Naturally Trees

16 October 2018

**TREE IMPACT STATEMENT:
St Francis Catholic College
130-160 Jardine Drive, Edmondson Park NSW**

Figure 2: Extract from Tree Management Plan (TMP01 B) – Source: Naturally Trees

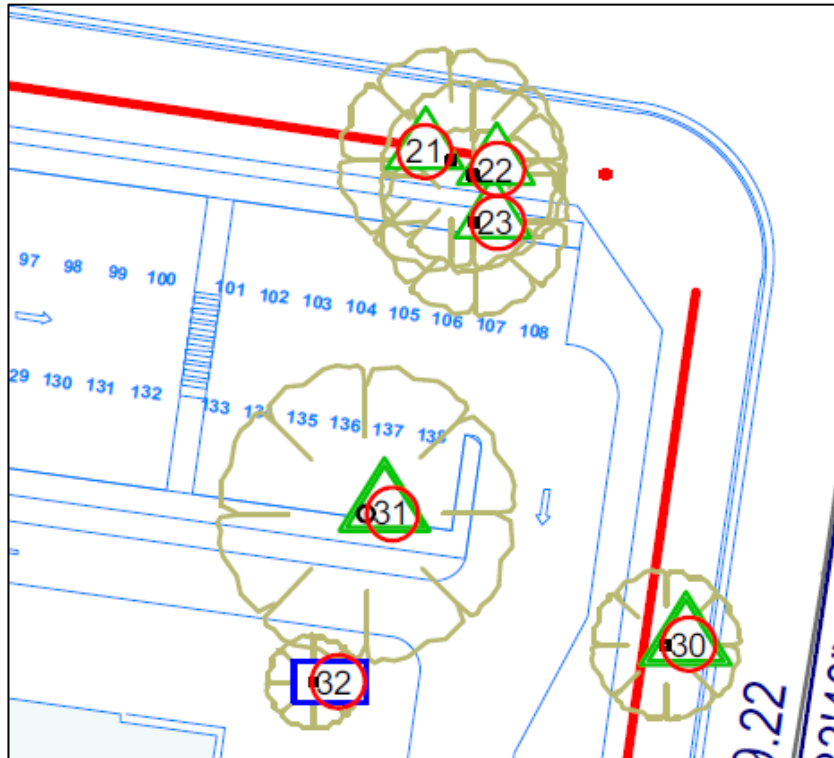
'The arborist's report has identified a number of mature trees as having a "high to very-high significance", display good health and condition. Insufficient details have been provided demonstrating the need for the loss of significant trees on site. Additional exploration of options to retain the trees on site is required or further details justification for their removal.'

Trees 21, 22, 23 and 31 will be directly impacted by the proposed works within the site but will also be impacted by the proposed road and footpath construction, located outside the site boundaries. A number of options have been considered to retain Trees 21, 22 and 23 however these trees will be indirectly affected by the road and footpath construction located adjacent to the site.

In conclusion I see no realistic way to successfully retain the subject trees under the current proposed works, within and adjacent to the subject site. The subject trees are very sensitive to construction impacts and changes in environmental conditions including, but not limited to the following: removal of existing vegetation, altered water tables due to level variations, ground disturbance from existing and previous construction activity and below-ground services.
